**Addendum No. 1**

RE: Contract ID C203127

**Rowan County (U-3459)**

SR-2541 (Klumac Road) At North Carolina Railroad In Salisbury

PROJECT	U-3459 - KLUMAC ROAD		
TITLE	TEMPORARY SHORING DETOUR TRACK SECTION NO. 2		
LOCATION	SALISBURY-SR 2541 (KLUMAC RD) of NCR/RNS		
DGN BY	CPB	RAILROAD	NORTH CAROLINA RAILROAD/NORFOLK SOUTHERN
DWN BY	RTJ	VAL SEC	V-8
CHK BY	RDE	DATE	8/12
		SCALE	1" = 20'
		MILE POST	MP 335.2
			SHEET 47 OF 51

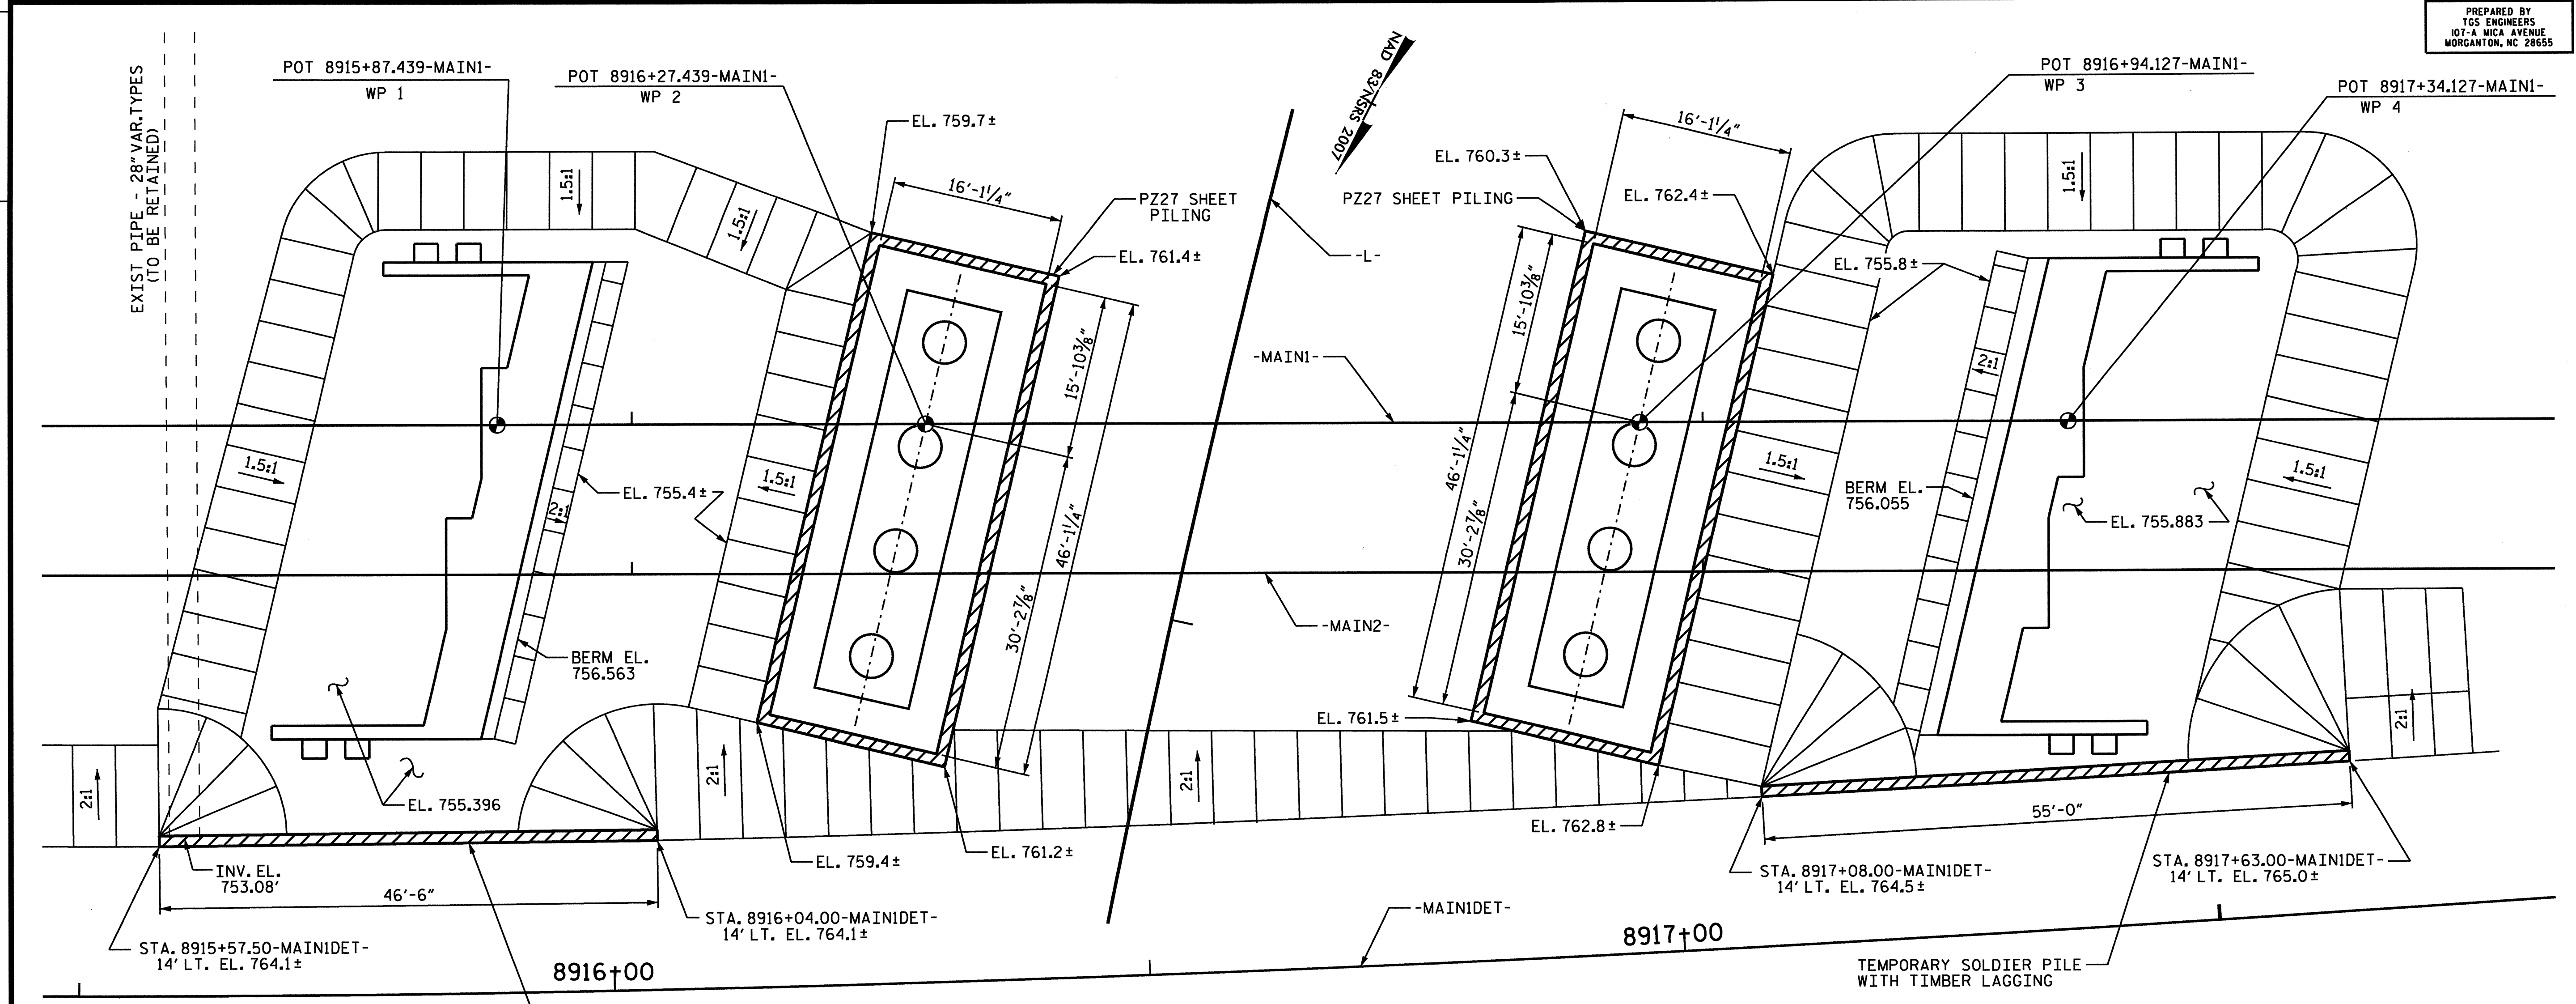
On Sheet Nos. 46 thru 51 the note concerning the condition of the shoring has been revised from "new" to "like new". Please void Sheet Nos. 46 thru 51 in your plans and staple the revised Sheet Nos. 46 thru 51 thereto.
